**re: Grading & Servicing Plan Review
Proposed Development
1592 Tenth Line Road – Ottawa**
to: Oligo Group – Mr. Ketan Dhawan – ketan.dhawan@olicobuilders.com
date: December 18, 2023
file: PG5632-MEMO.03

Paterson reviewed the following drawings prepared by Tatham Engineering during the preparation of this memo:

- ☐ Site Grading Plan – Bridor Developments – 1592 Tenth Line Road – Project No. 522677 – Drawing No. C200 - Revision 4 dated December 2023.
- ☐ Site Servicing Plan – Bridor Developments – 1592 Tenth Line Road – Project No. 522677 – Drawing No. C300 - Revision 4 dated December 2023.

DRAWING:
SITE GRADING PLAN

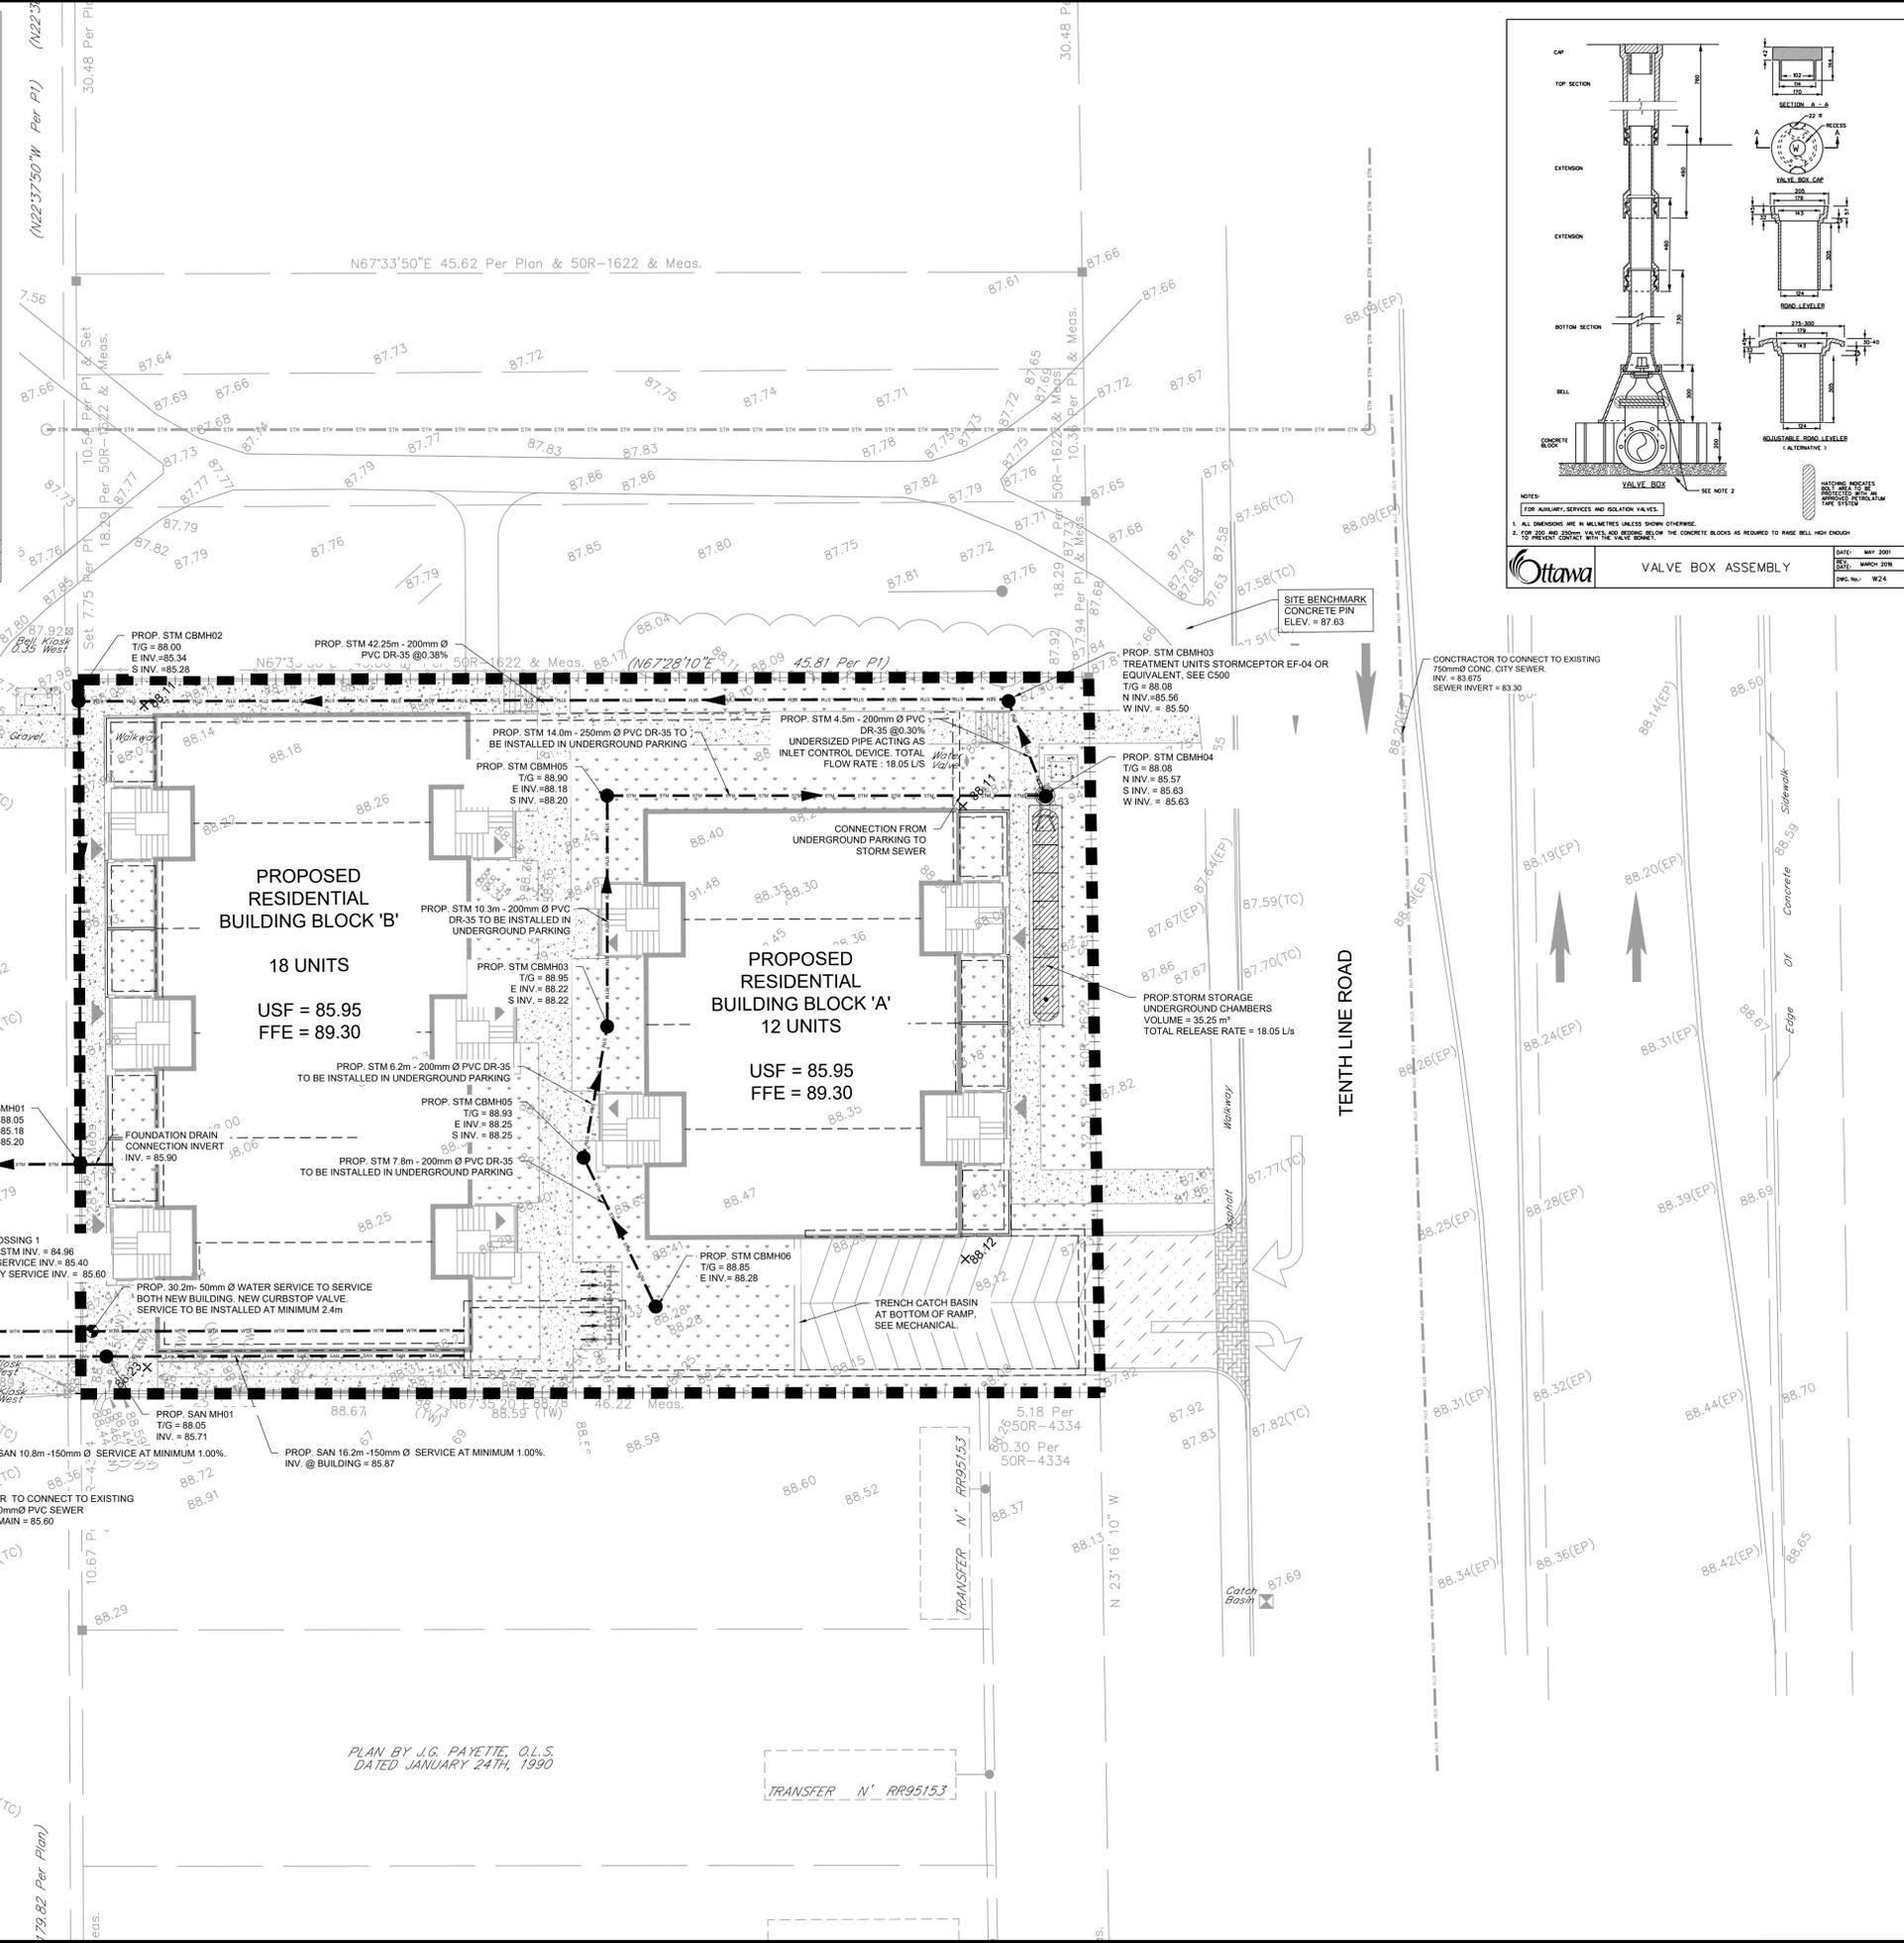
Based on our review of the above-noted Site Grading Plan, the proposed grading at the subject site is within the recommended permissible grade raise restriction of 1.0 m provided in the Geotechnical Investigation Report, referenced above. Therefore, the proposed grading is considered acceptable, from a geotechnical perspective, and no lightweight fill or other considerations are required to accommodate the proposed grading.

DRAWING:
SITE SERVICING PLAN

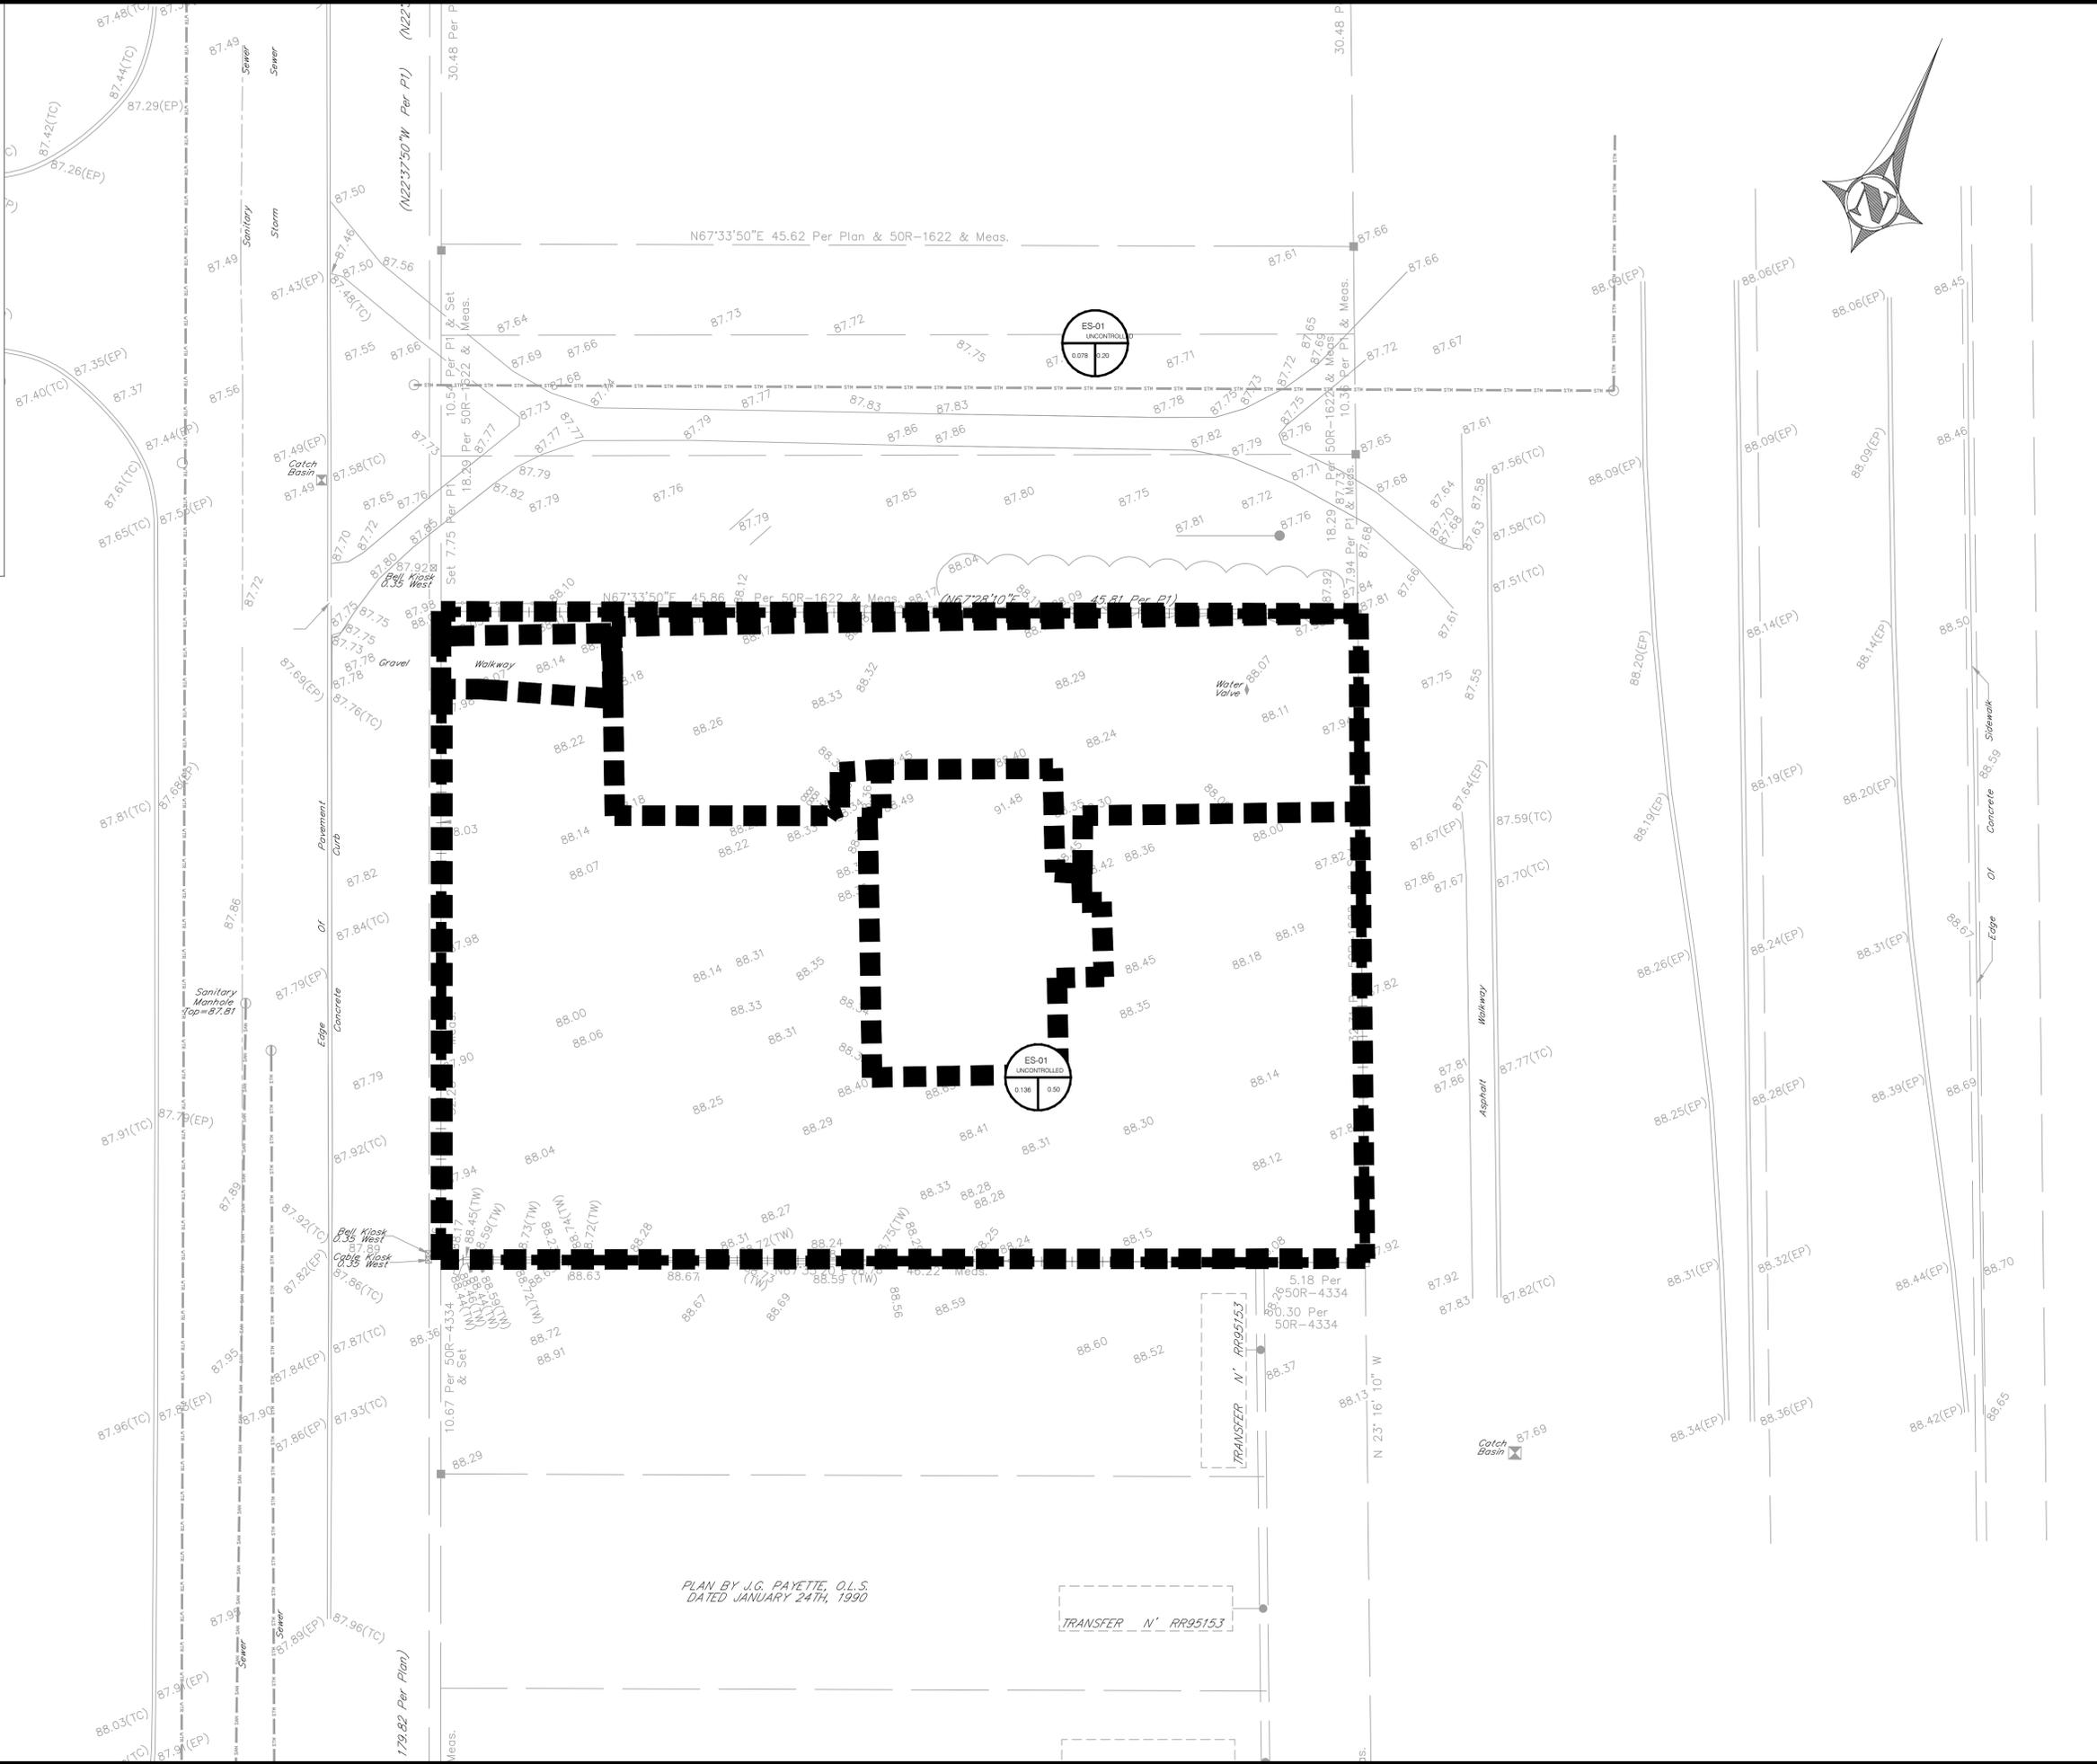
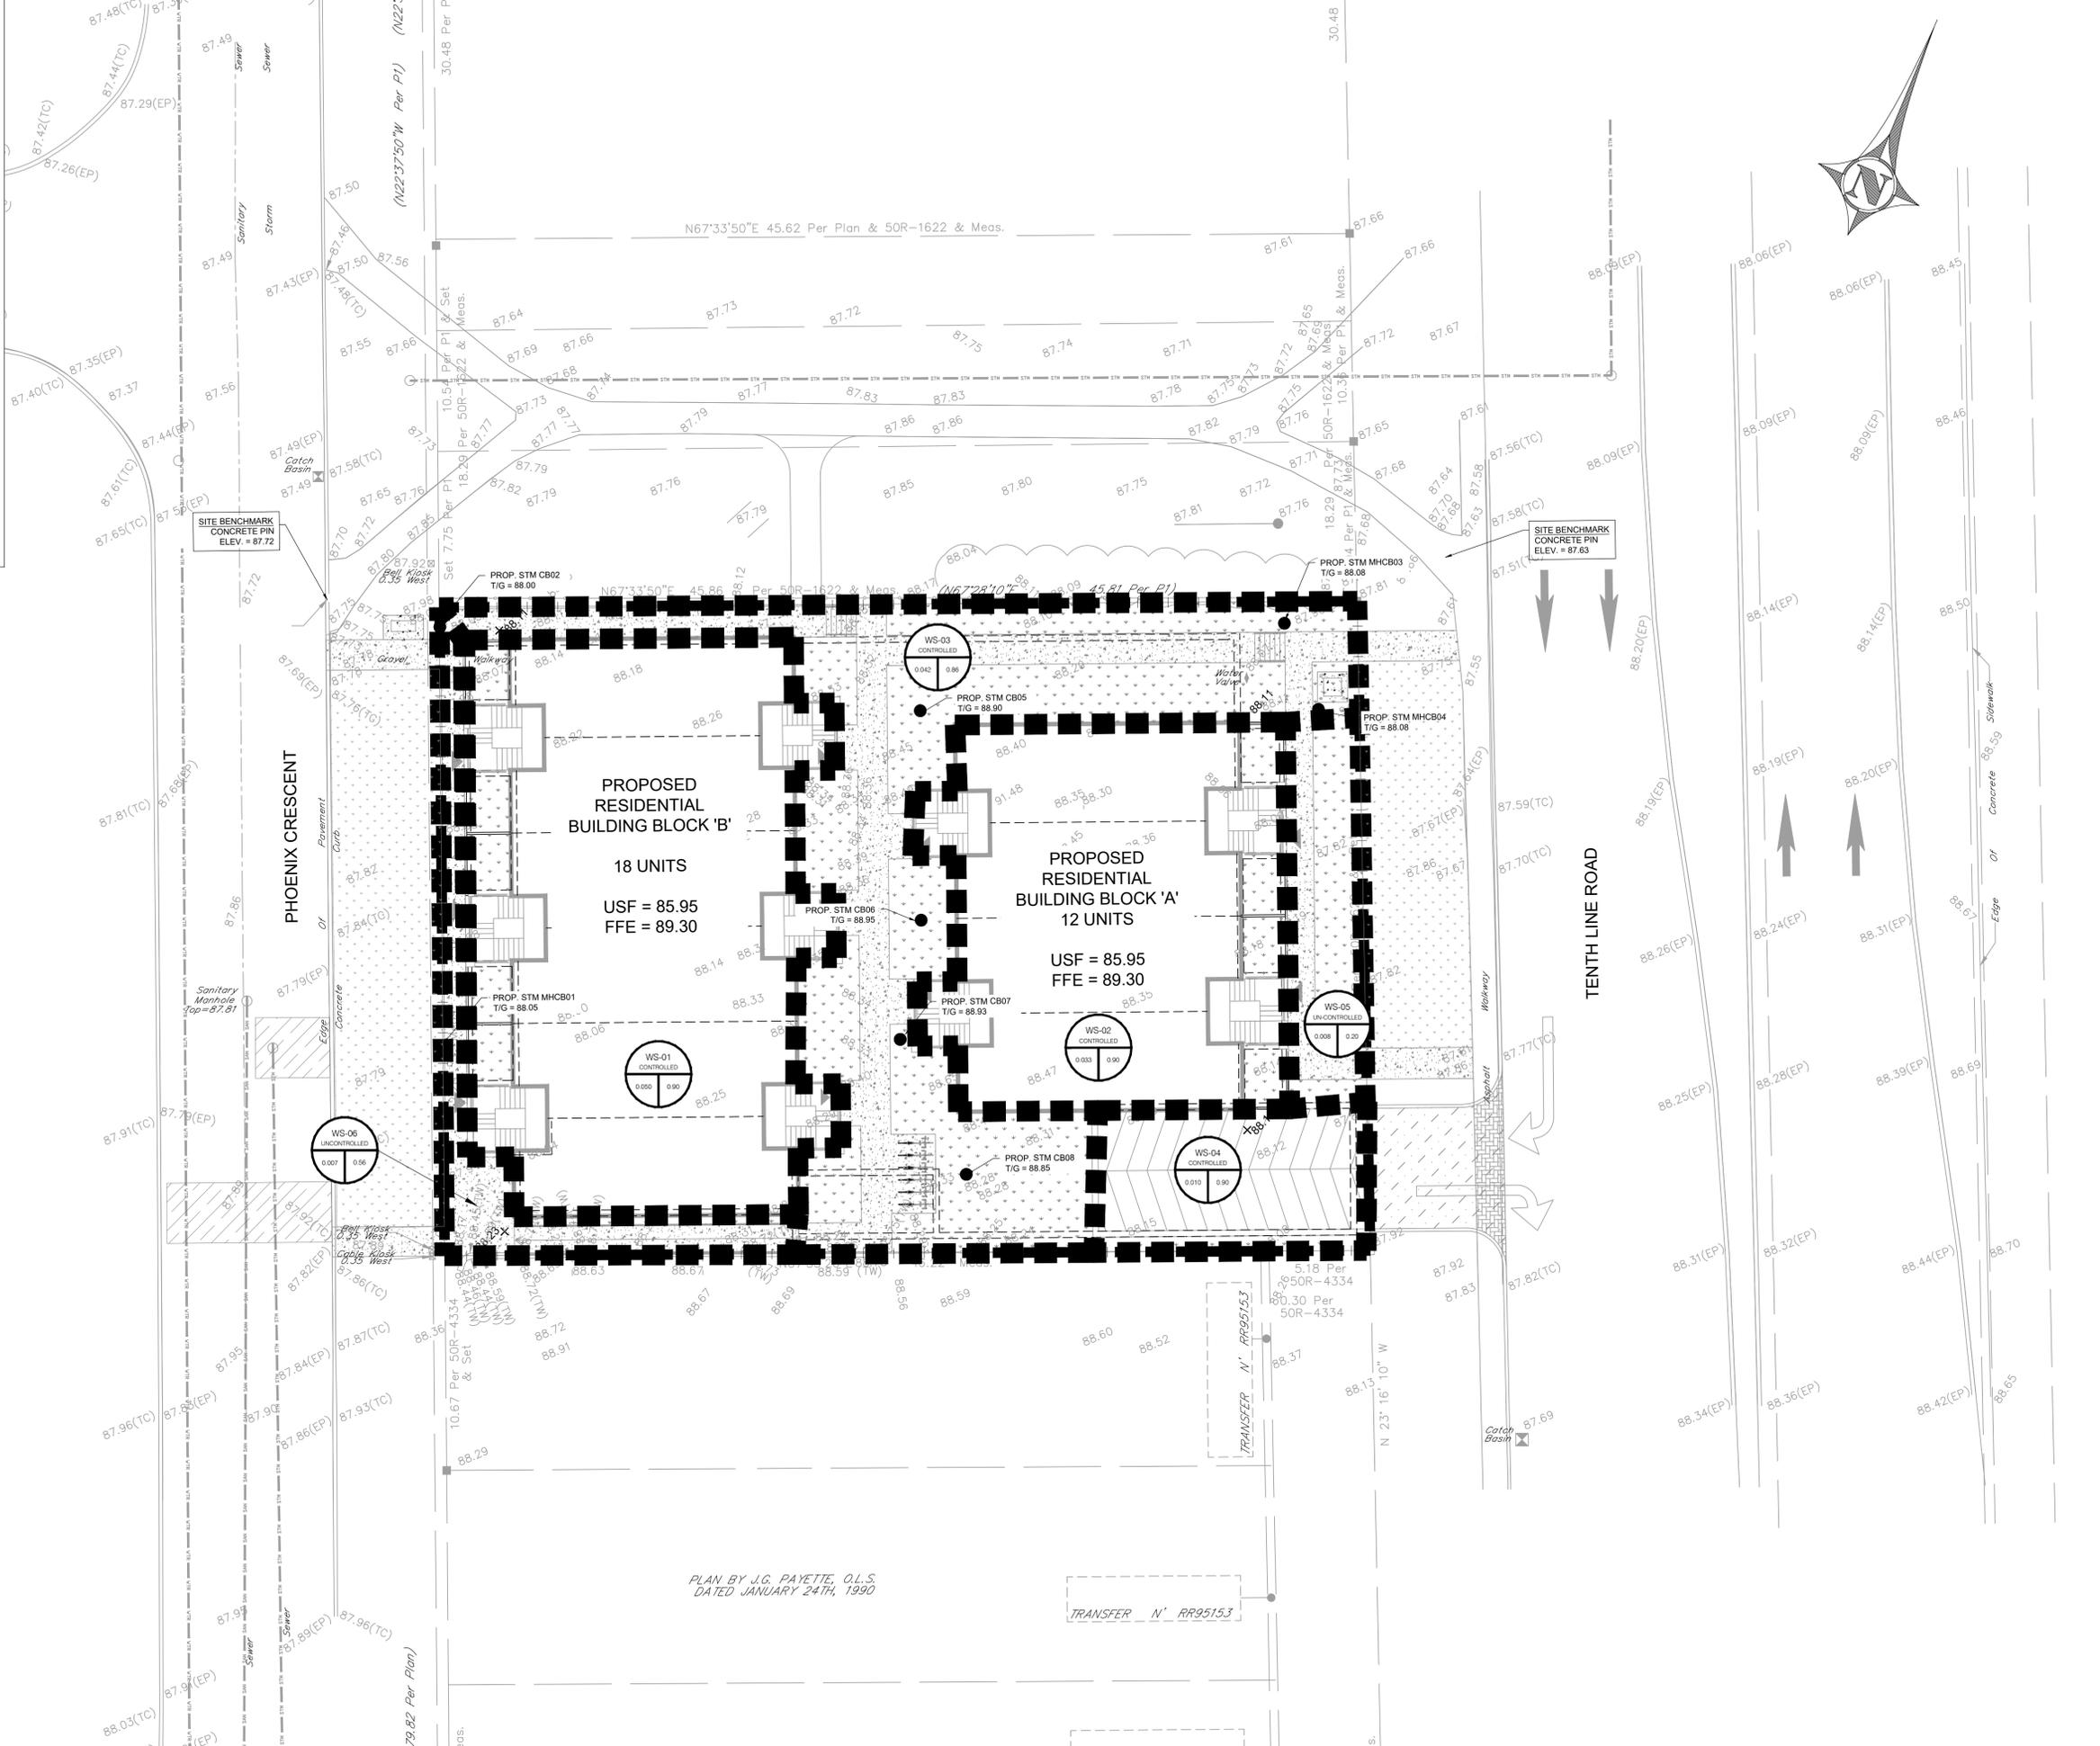
In reviewing the above-noted Site Servicing Plan, the proposed servicing pipes will generally be located at depths greater than 2.2 m below finished grades.

The only exception is the perforated subdrain from LCB04 to LCB05 which will have about 1 m of soil cover. This pipe should be boxed with a 100 mm thickness of SM rigid insulation in order to provide adequate insulation.
